**WELWYN HATFIELD BOROUGH COUNCIL – DEVELOPMENT MANAGEMENT**  
**DELEGATED REPORT**

<b>APPLICATION No:</b>	<b>S6/2012/1258/FP</b>
<b>APPLICATION SITE:</b>	<b>Wildwood, Kentish Lane</b>

This application seeks full planning permission for the erection of a swimming pool enclosure. The footprint of the new building would measure approximately 17.6m x 10.3m (181sqm measured externally) and would adjoin an existing outbuilding which houses a changing room and shower. The swimming pool enclosure would feature a flat roof concealed behind a parapet wall measuring approximately 3.6m in height. Externally the enclosure would be finished in white render with stone cladding detail to match the main house.

Client	Mr B and Mrs C Bester
Description	
Project	Wildewood Essendon AL9 6JG
Drawing	EXISTING Plans
Date	Feb 2011
Scale	1:100
Sheet size	A1
Drawn	DT
10424-s003-A

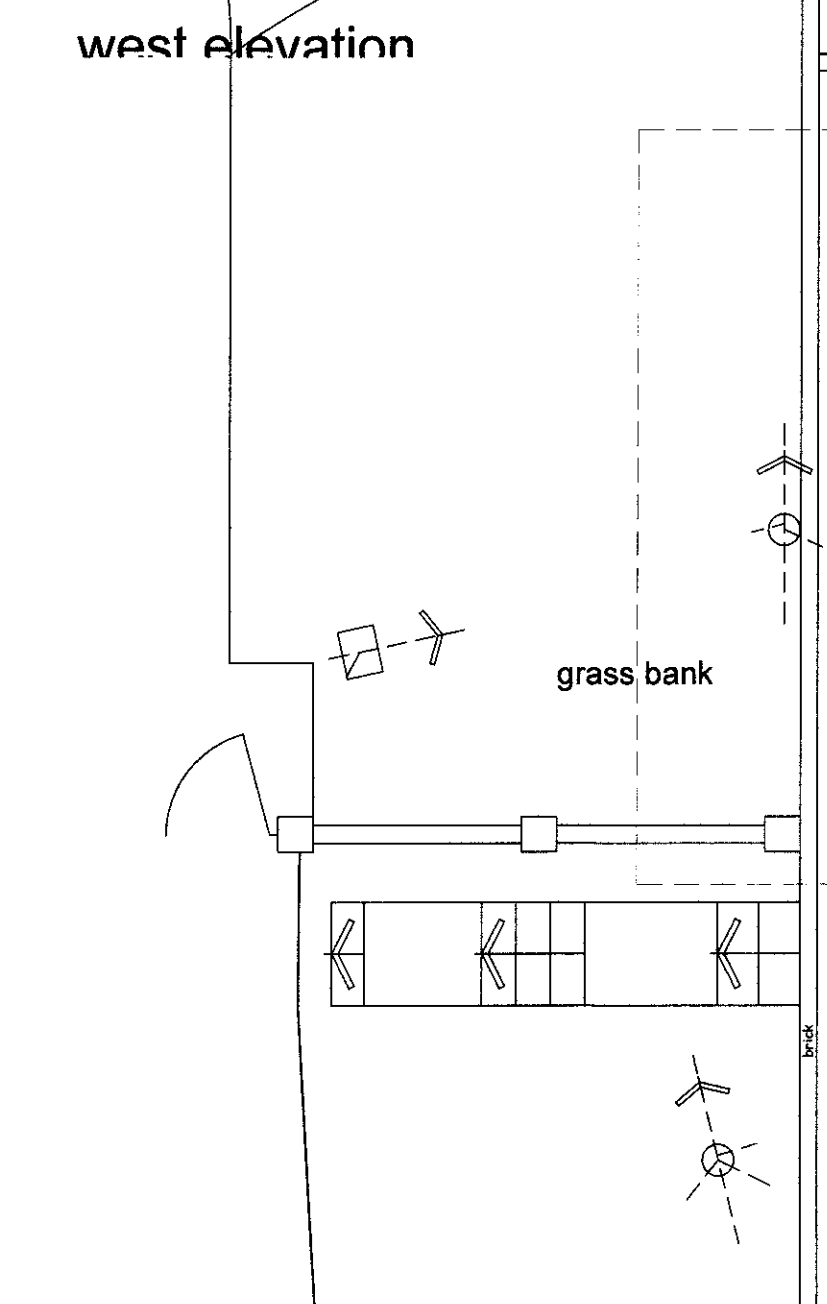
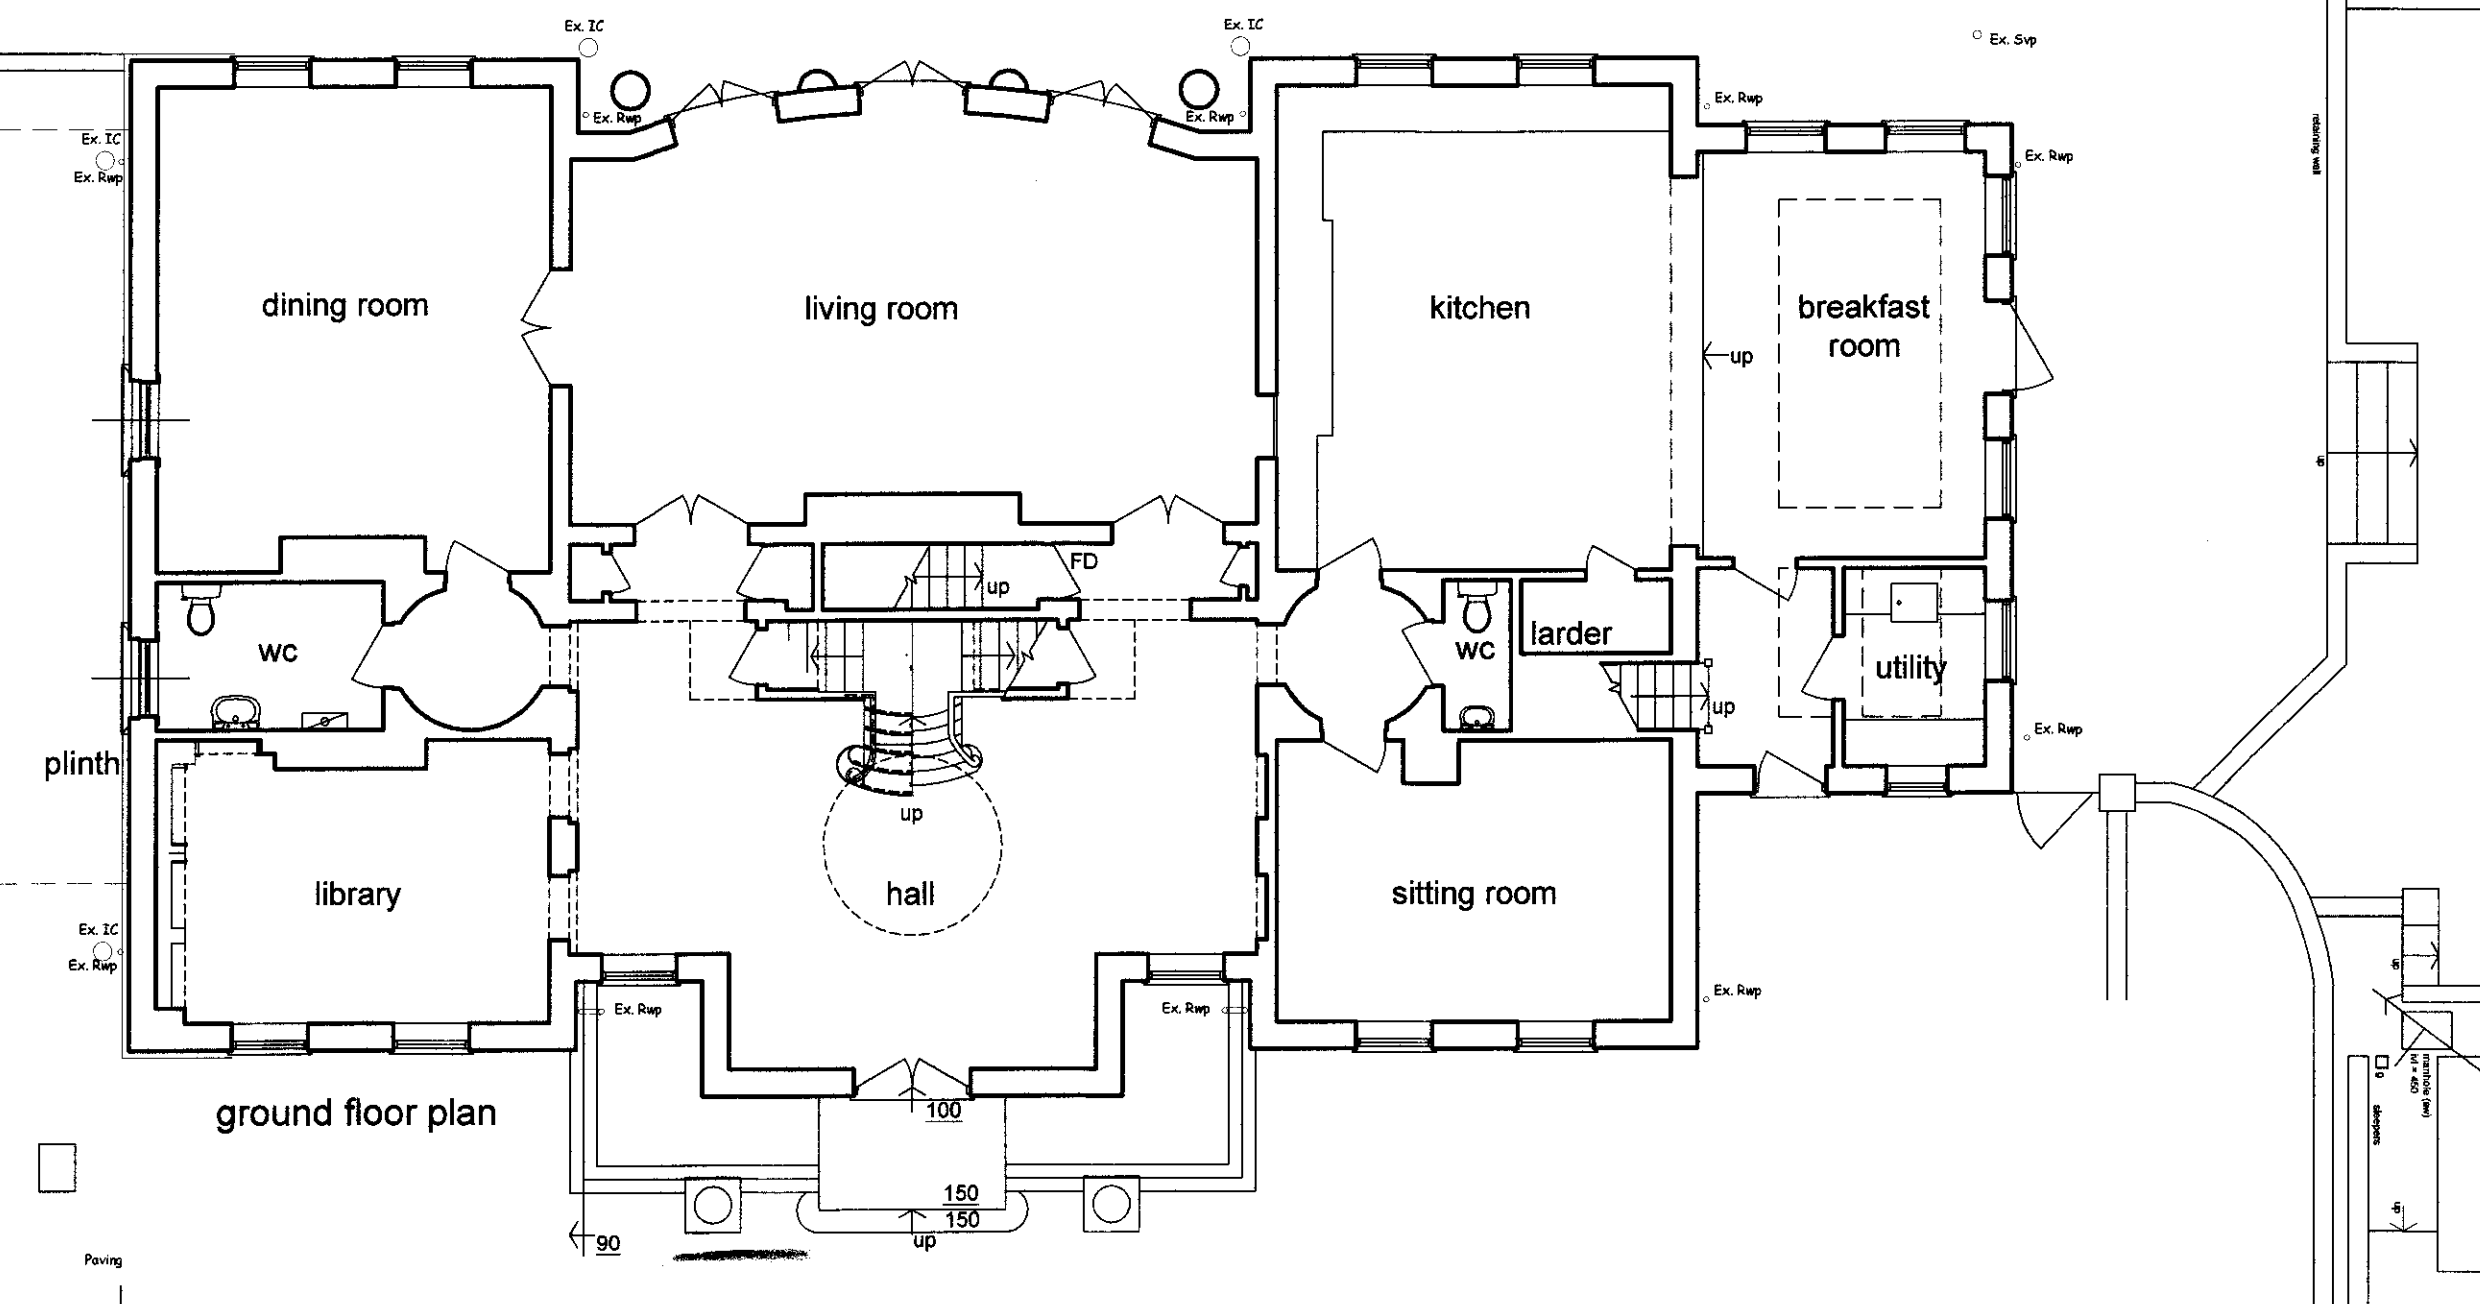
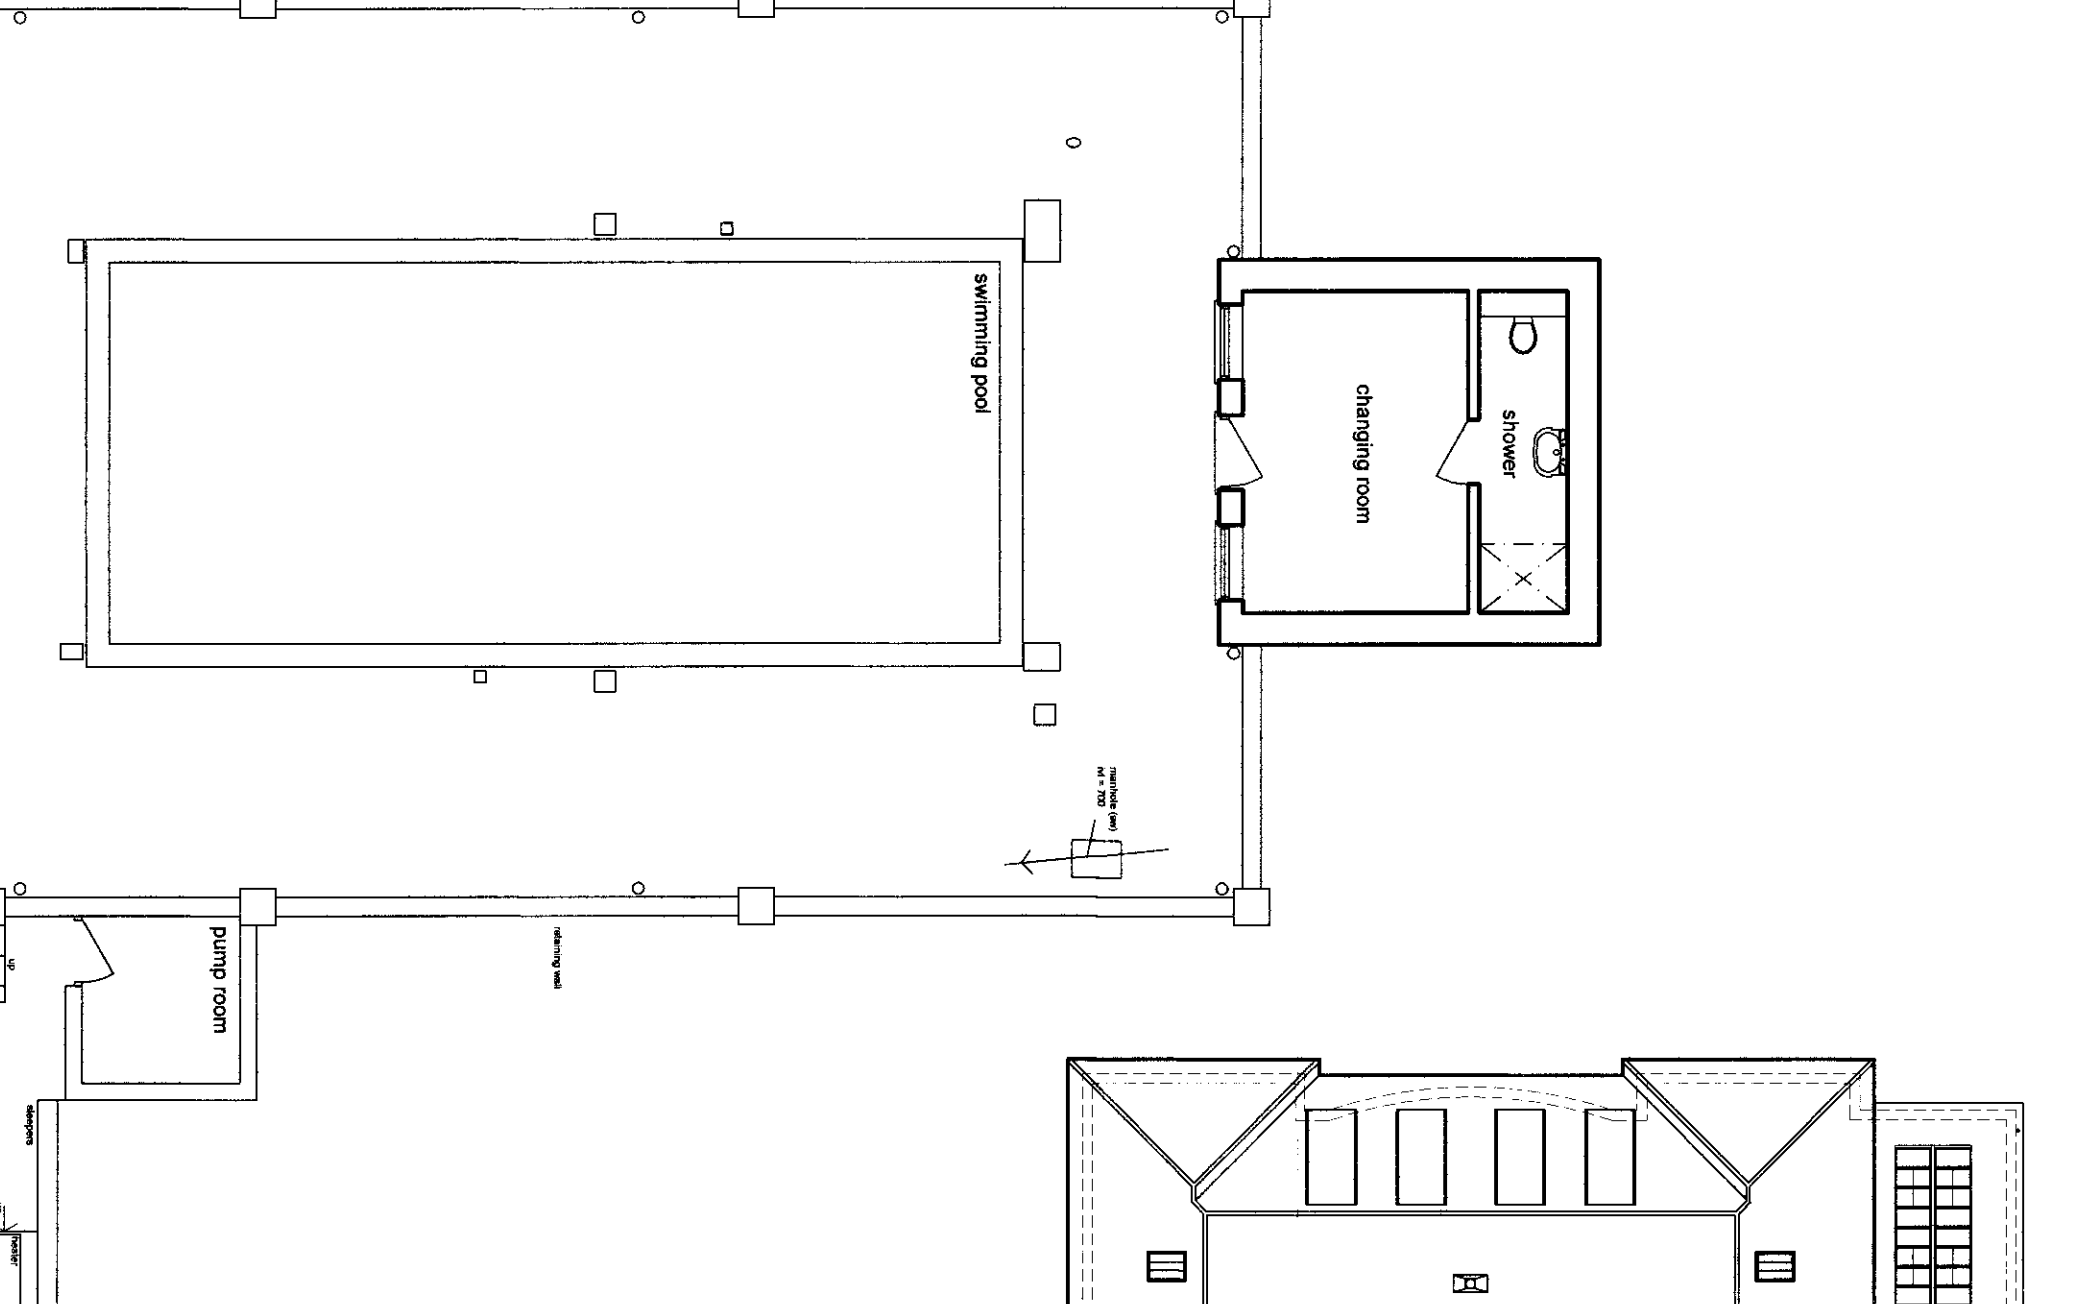
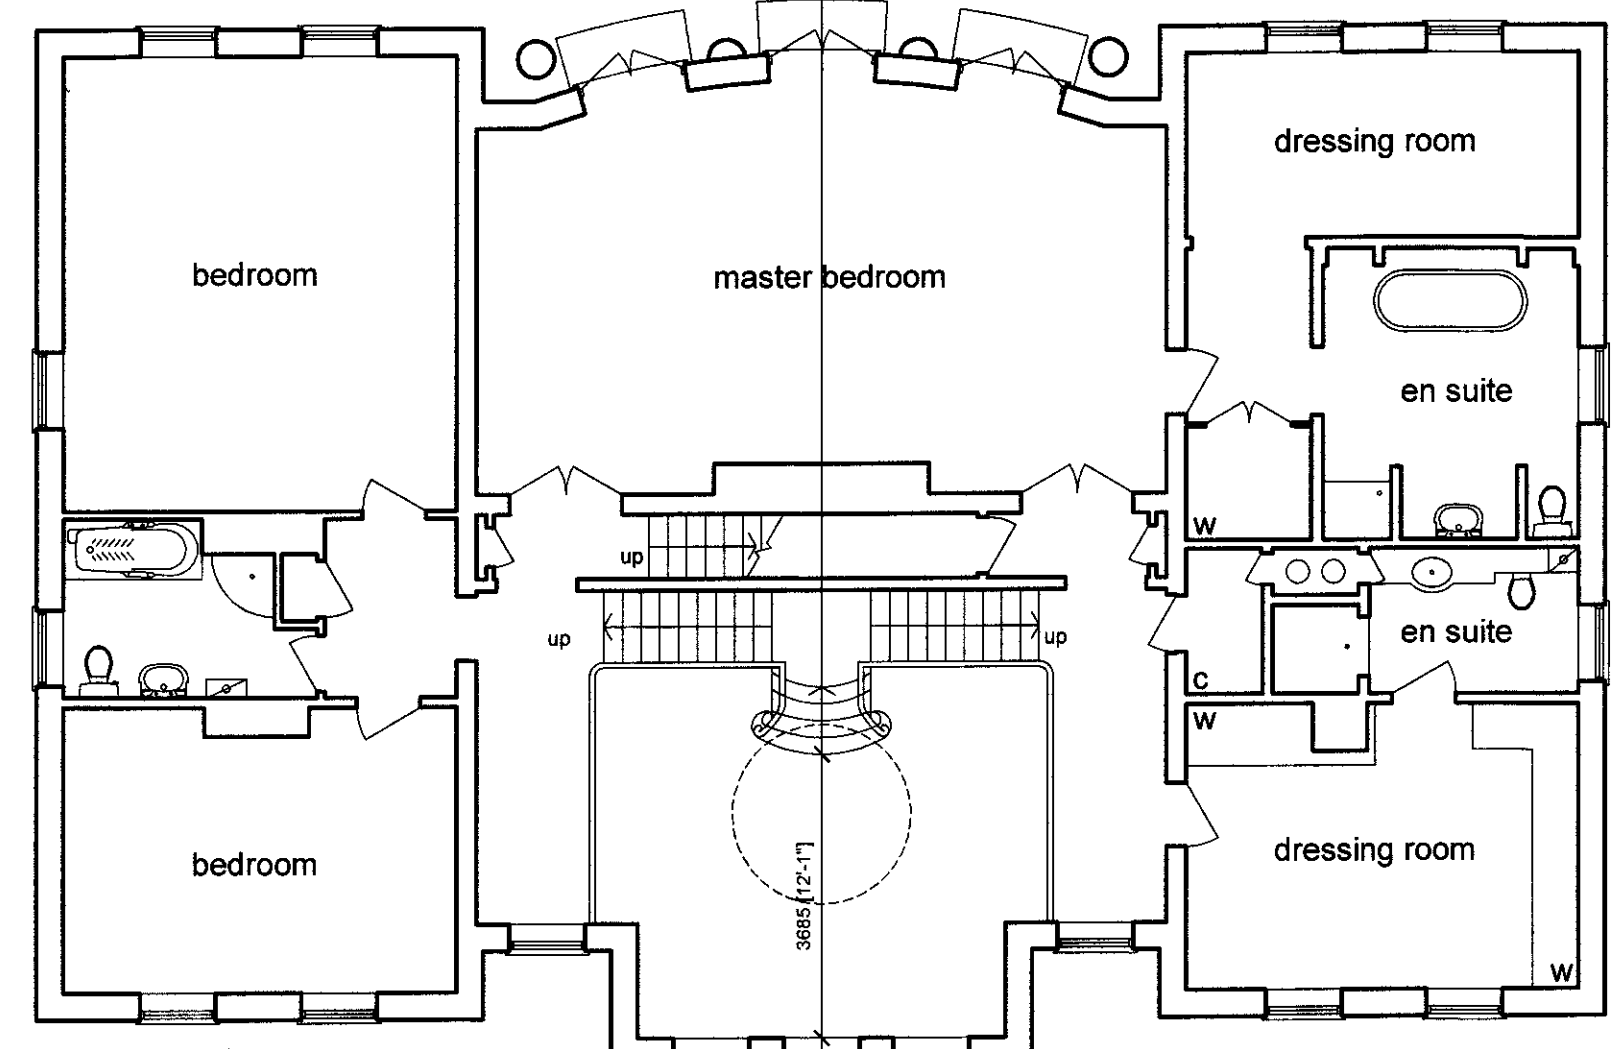
At the time of the site visit an orangery extension was under construction to the north east side of the application dwelling (planning reference S6/2011/0208/FP granted on appeal). Prior this, the dwelling itself has not been extended since it was built as a replacement dwelling. Although the dwelling had not previously been extended, it is relevant that the roof space has been converted to provide additional habitable

accommodation as shown on drawing 10424-s003-A. Whilst it is acknowledged that planning permission S6/1052/97/FP included the introduction of “attic dormers”, these were intended to provide natural light to the attic which was not included in the calculation of habitable floor area when granting permission for the replacement dwelling (the Officer’s report and application form for planning permission S6/1052/97/FP are available on file).
